The Member Secretary,
Madras Metropolitan
Development Authority,
No.8, Gandhi Irwin Road,
Egmore, Madras-600 008.

Letter No.L1/14077/92

Sub: MMDA - Planning permission - Sub-division
of house sites in Plot No.348 into two
plots, S.No.116/1pt. of Valasaravakkam,
Ramakrishna Nagar - Development charges -
to be remitted - Regarding.

PLAN SHOWING THE PROPOSED  
 SUB-DIVISION IN PLOT NO. 348 AT  
 PLAY GROUND ST, RAMAKRISHNA  
 NAGAR IN S.NO.116/1 OF VALASARA-  
 VAKKAM VILLAGE, MADRAS.

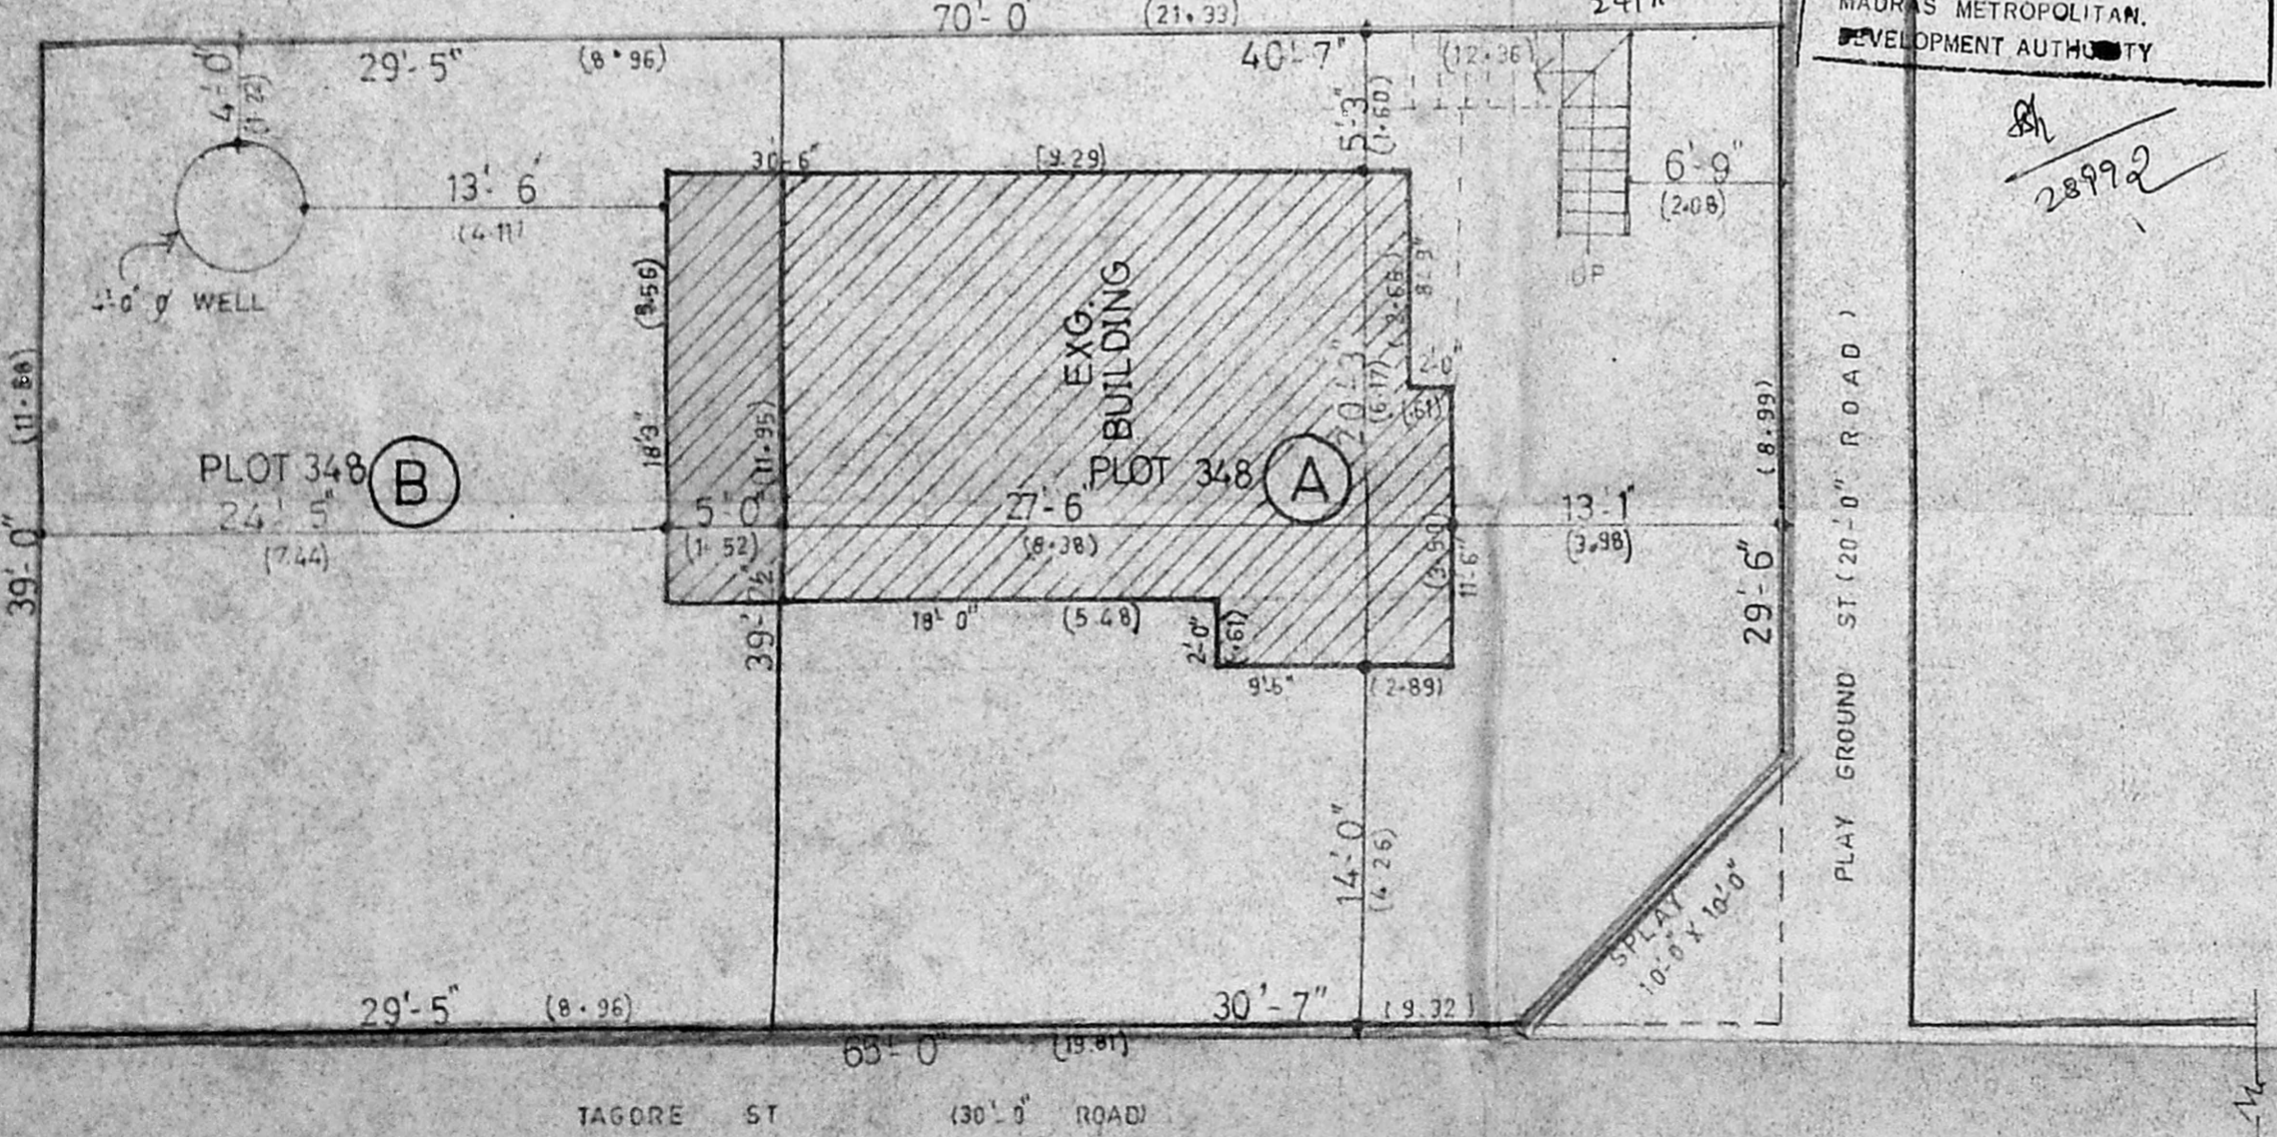
The proposal received in the reference cited for sub-
division of Plot No.348 into two plots, Ramakrishna Nagar,
Survey No.116/1pt. of Valasaravakkam village was examined and
found approvable relaxing the violation of plot extent and plot
frontage subject to the condition that the existing building
shown for demolition should be demolished before the sanction
of the plan by the local body (ie. Executive Officer, Valasara-
vakkam Town Panchayat).
